Addendum #1

**The Parkside Neighborhood Center
and Affordable Housing
Mellen & Grant Streets,
Portland, Maine 04101**

February 12, 2004

T:\00\_TFH Projects\PP\0114\_Mellen Grant\Send\Revise\Revised\SC20210 Bid\docs\CAD\BUILDING\DWG\A-B-S7.dwg, Model: 2/27/2004 11:28:38 AM

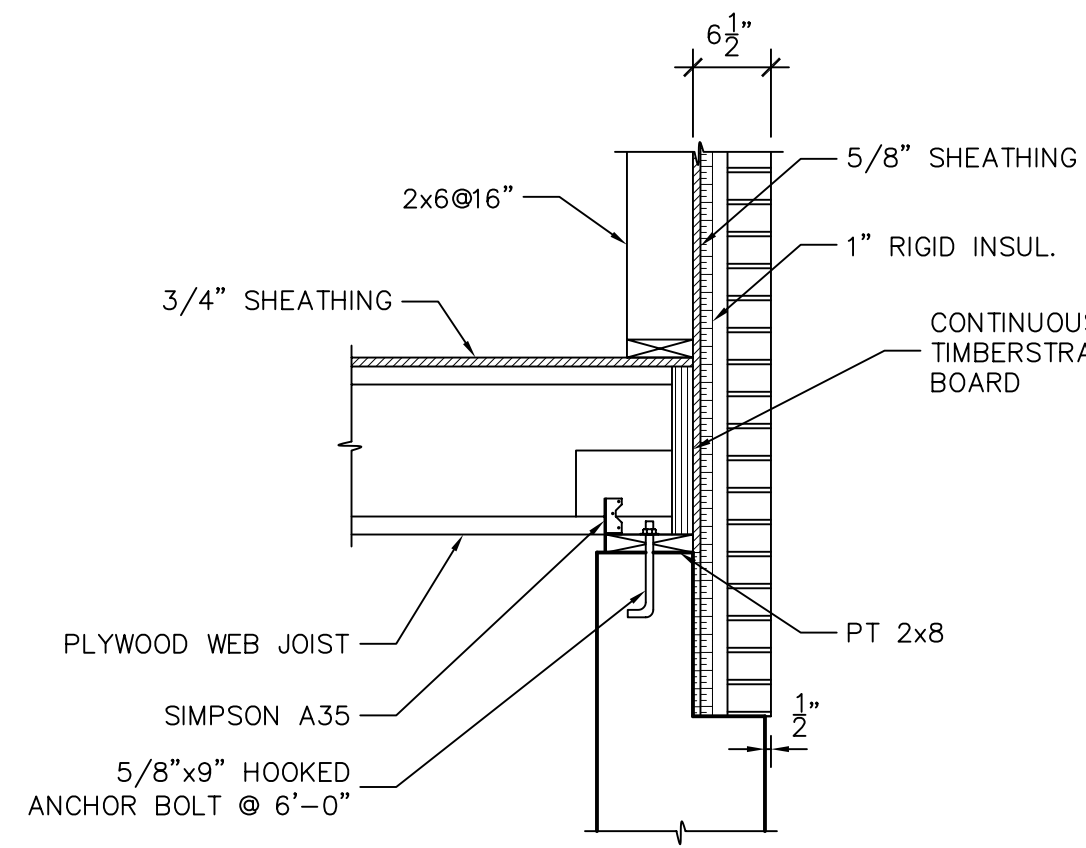
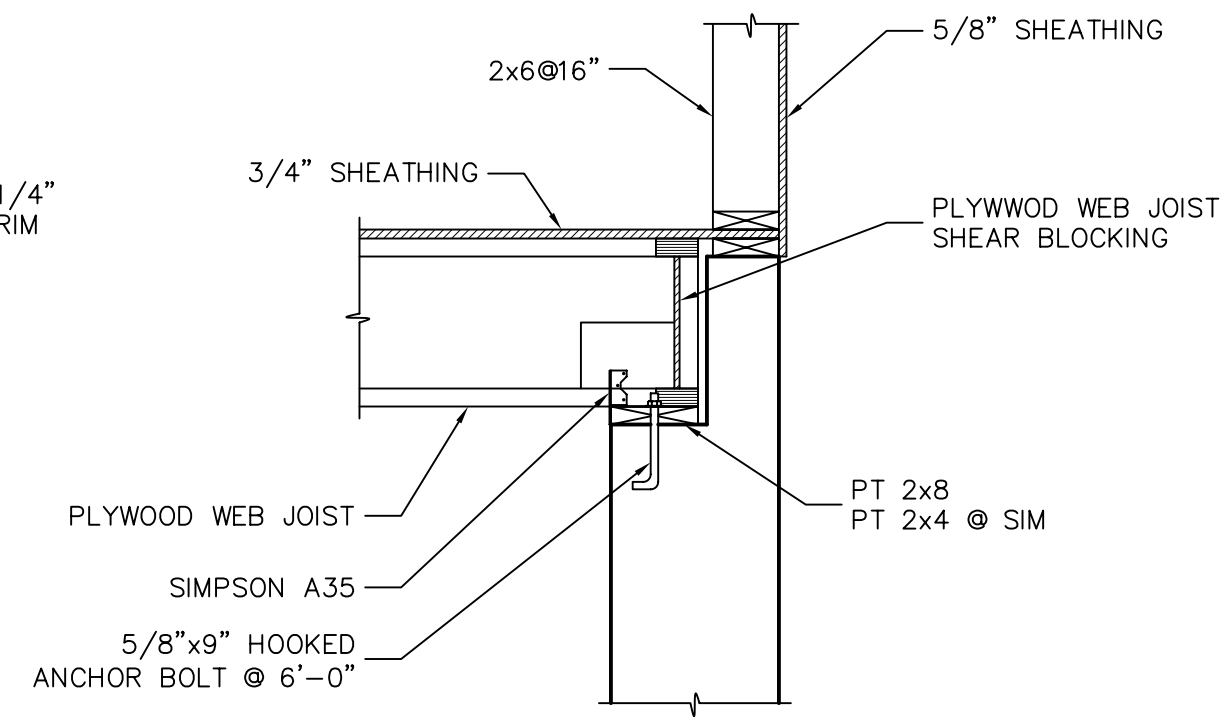
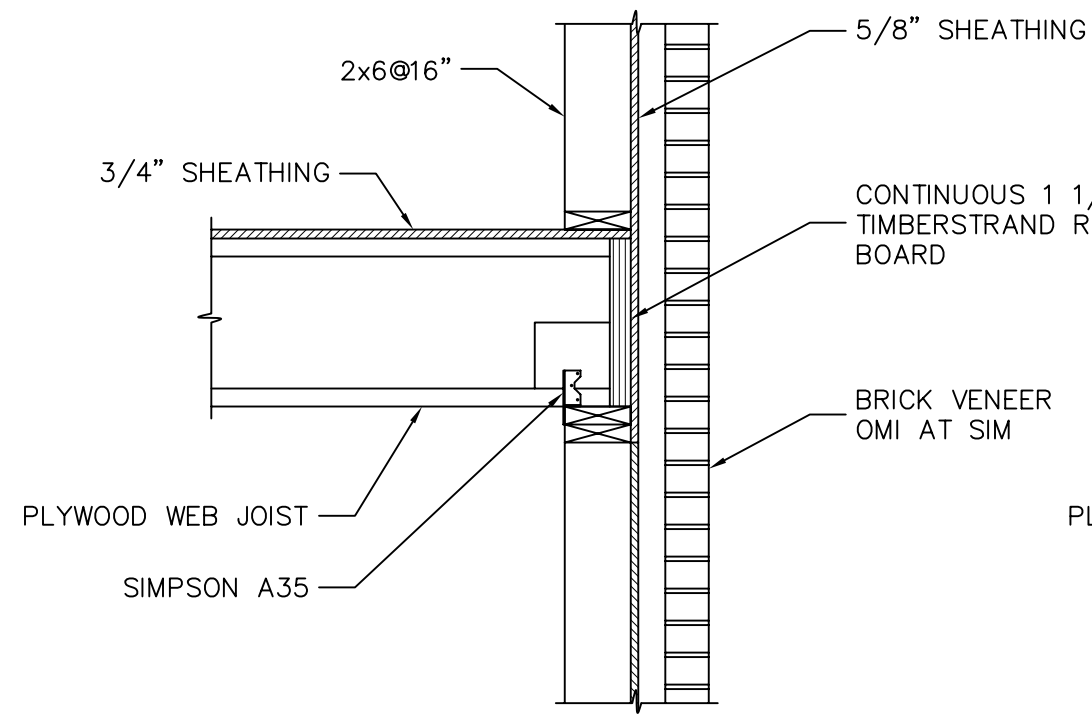
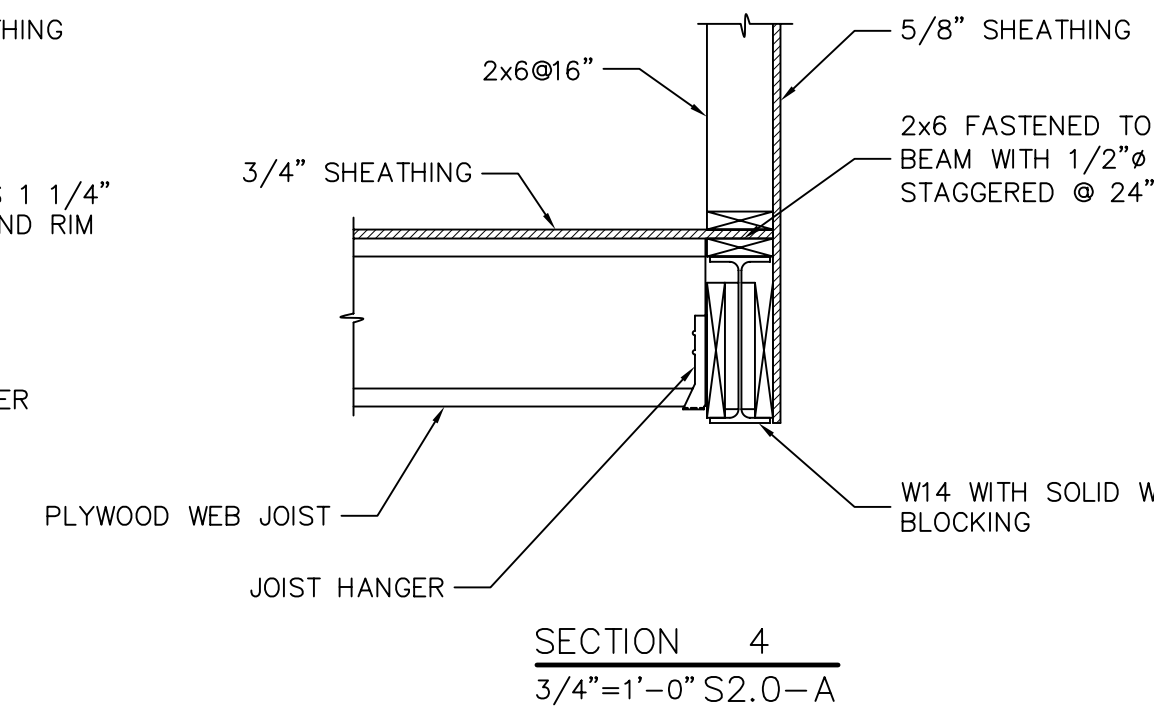
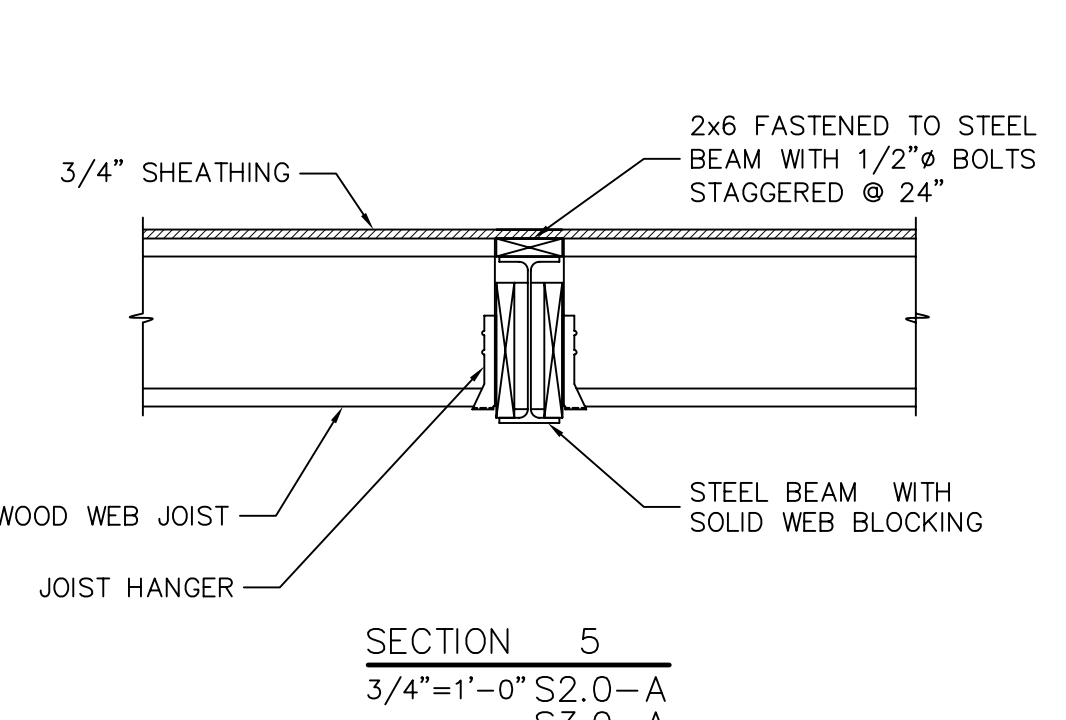
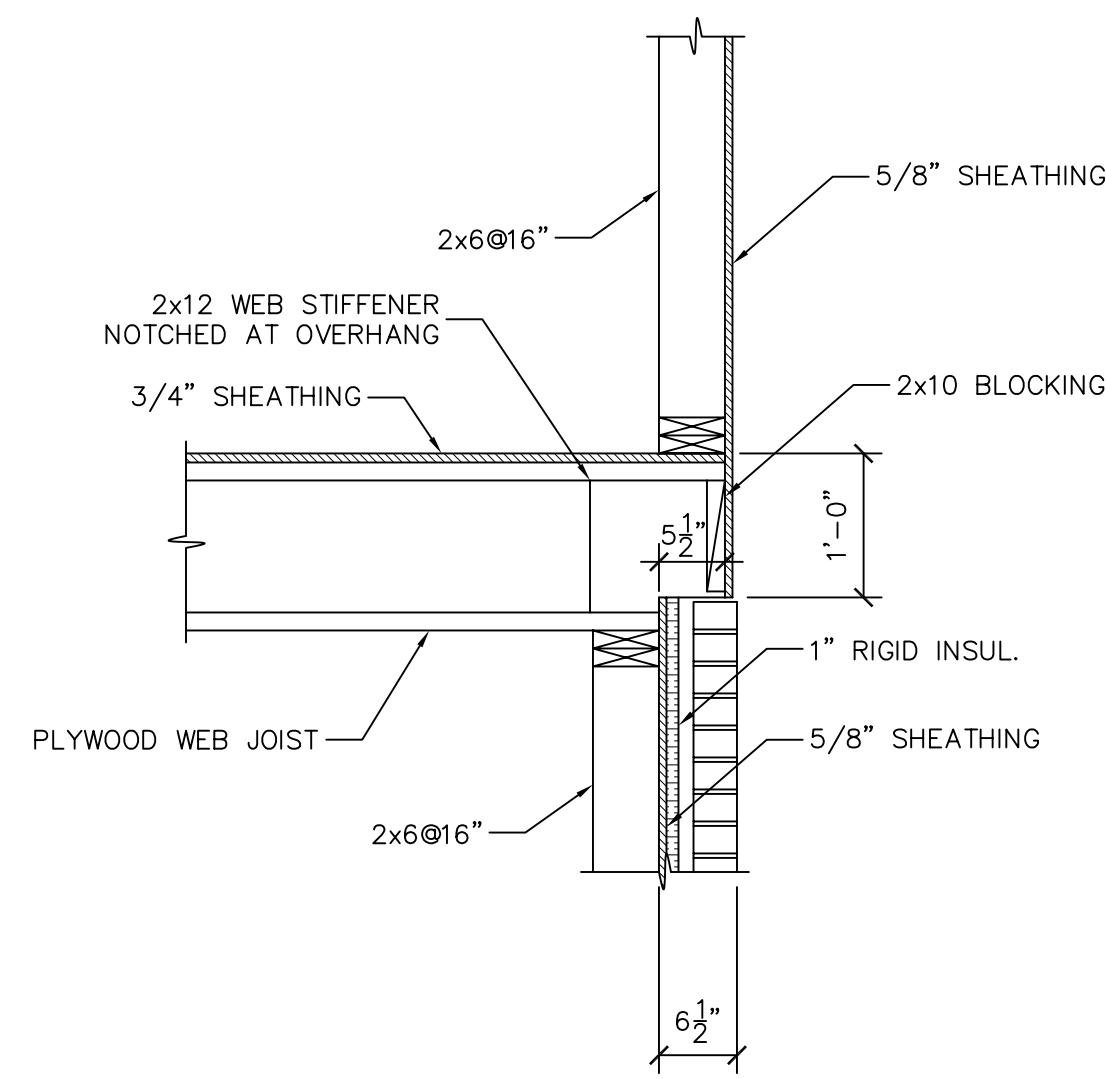
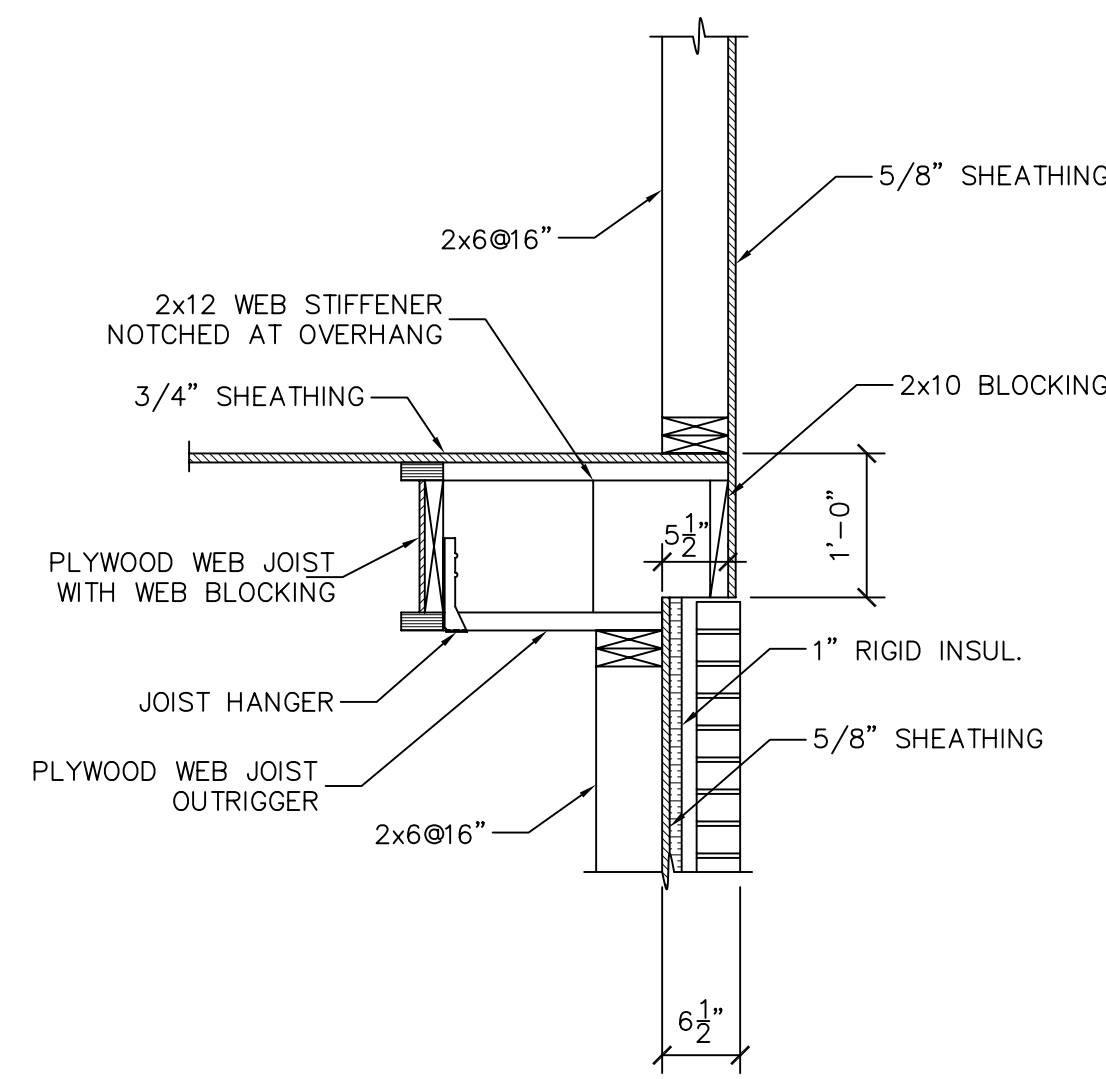
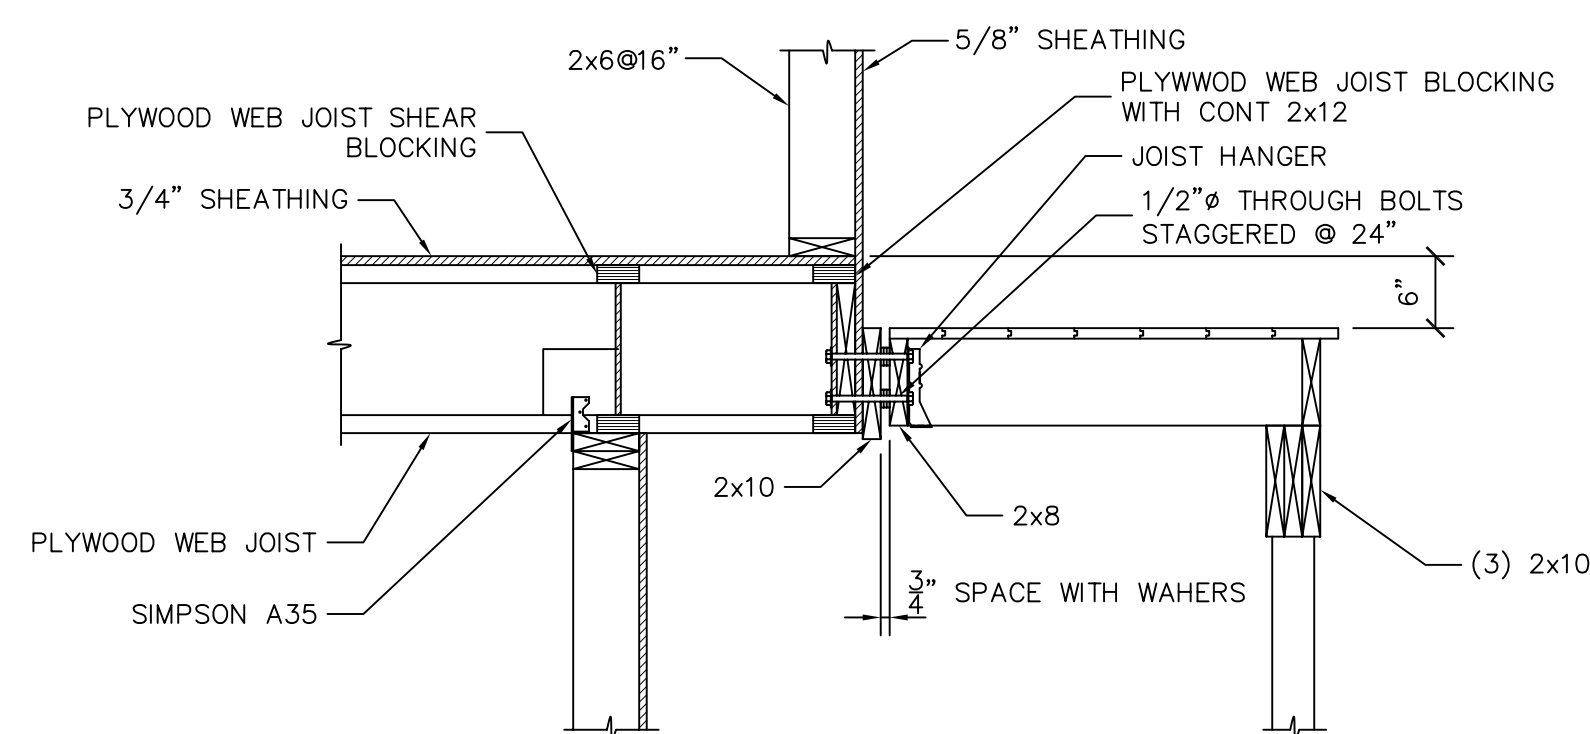
- 1-64 S0.1 Bldg A/B INSERT Joist Hanger Schedule per SK6.
- 1-65 S1.0 Bldg A Revise footing elevations and step locations per SK1.
- 1-66 S1.0 Bldg B Add footings and foundation walls for porches per SK2.
- 1-67 S1.0 Bldg B Add chimney footing per SK3.
- 1-68 S3.0 Bldg B Add porch framing per SK4.
- 1-69 S7.0 Bldg A/B INSERT Section 9 per SK5
